Our Ref: 1-046/001
03 February 2021

RE: NORTHAW HOUSE, HATFIELD – RESPONSE TO HERTFORDSHIRE LEAD LOCAL FLOOD AUTHORITY CORRESPONDENCE (REF; 6/2020/3439/COND, DATED 01 FEBRUARY 2021)

Trapped Gully Detail (1:20)

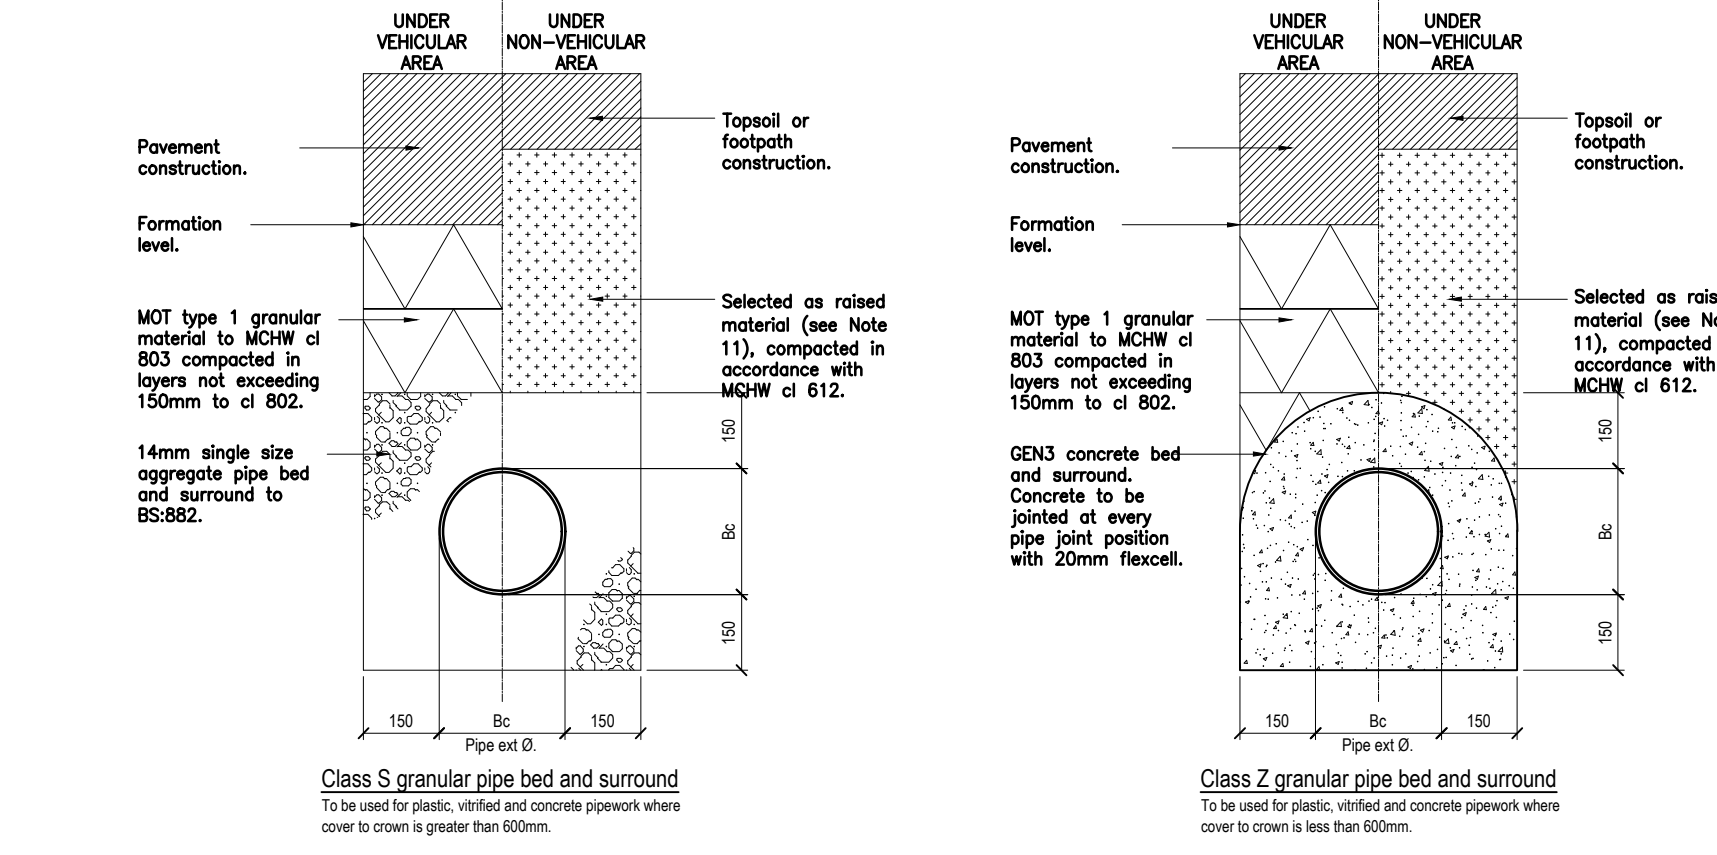
3. *"Please could the applicant also clarify how the Swale North of this eastern Rd connect to the wider drainage network as we understand the previously approved swale was to connect to the site network at the western end of the swale, but this is no longer indicated"*

The swale to the north of the access road will not be positively drained. The reason for this is due to the swale going against the natural topography resulting in excessive invert depths (around 3m deep) resulting in large earthworks. The swale will still provide an exceedance flow function however and hence why it is still shown on the plans. The road area in question will drain via a trapped gully system connected to pipes 12.000 and 12.001.

Typical Pond Detail (1:50)

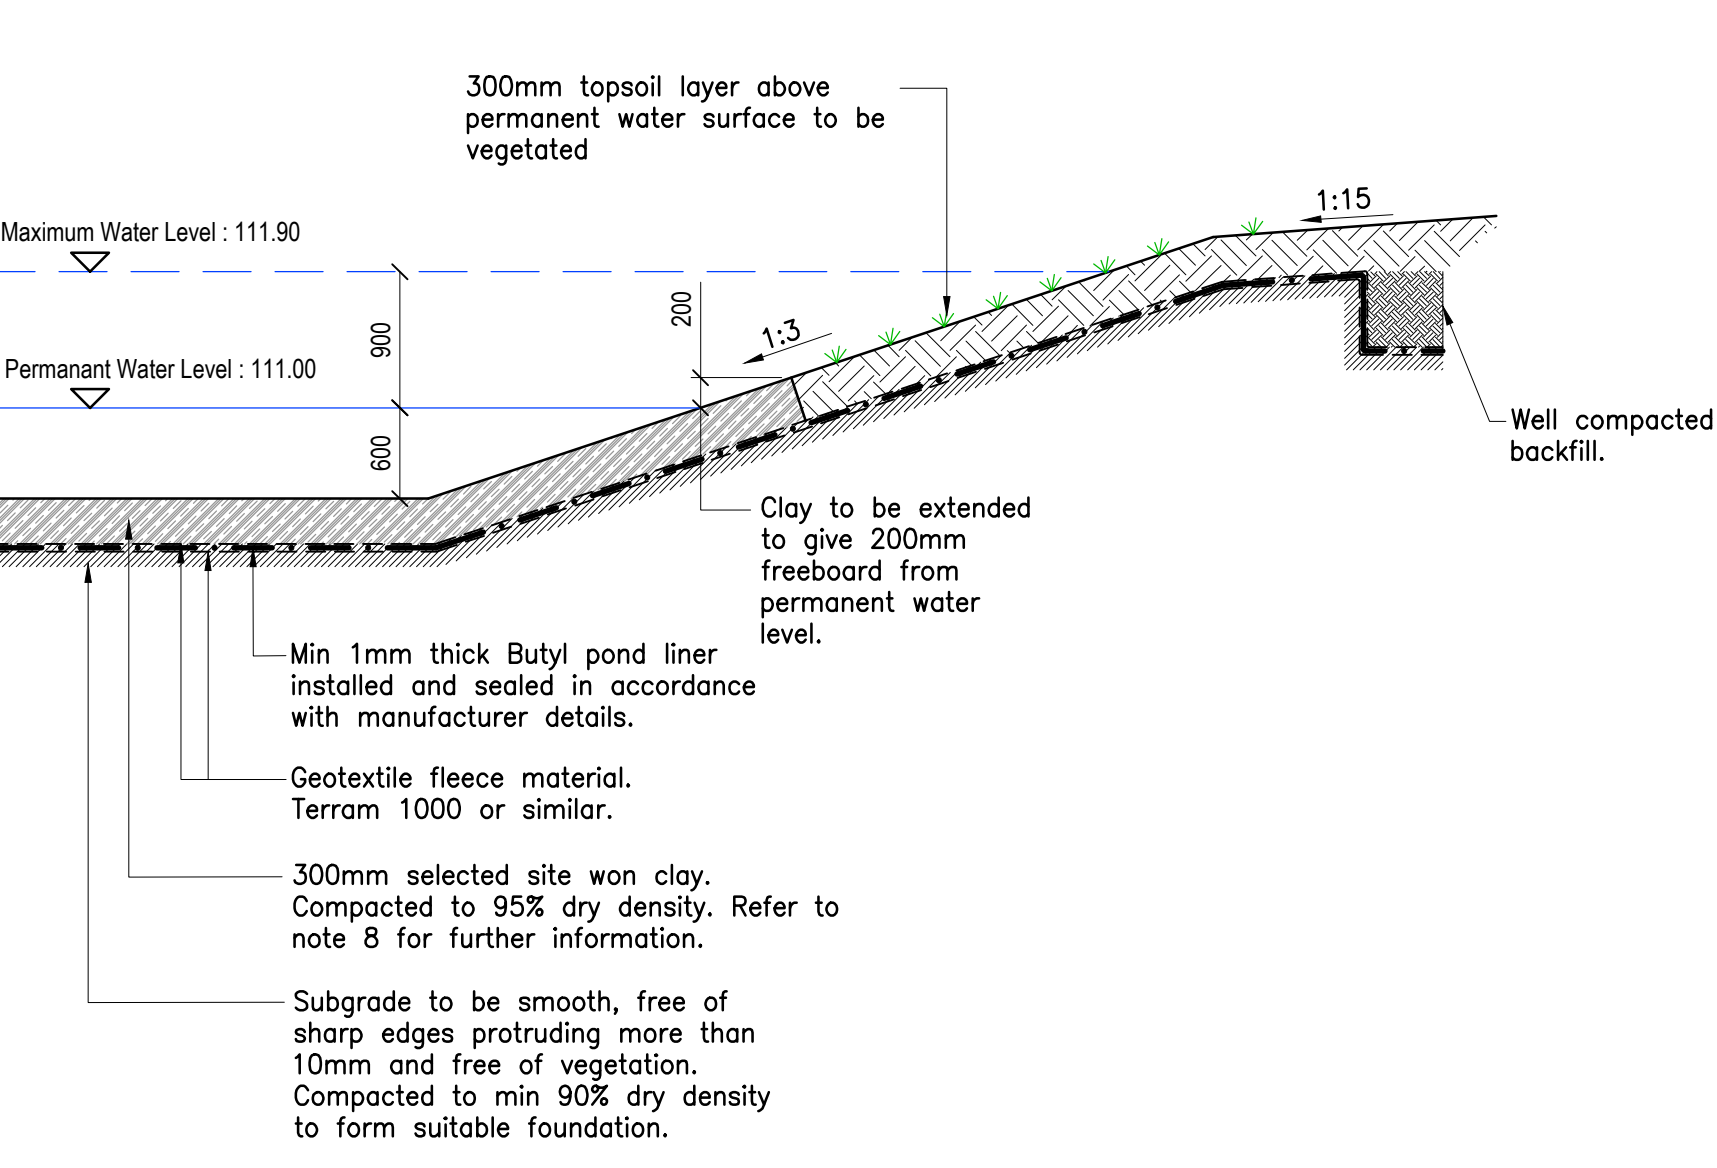
1. *“We require half drain down times to be less than 24 hours or evidence that the proposed network can manage for a 1 in 100 + 40% climate change storm followed by a 1 in 30 year event”*

It can be seen from the Causeway FLOW results (attached to this letter) that the storage volumes within the pond for the 30+0%cc event and 100yr+40% climate change event are as follows;

- 1:30yr storm event = 385.35m³
- 1:100yr+40%cc = 799.13m³

Total = 1,185m³

There is a total of 1,305m³ available within the pond, allowing ample storage for both the 30+0%cc event and 100yr+40% climate change to occur consecutively.
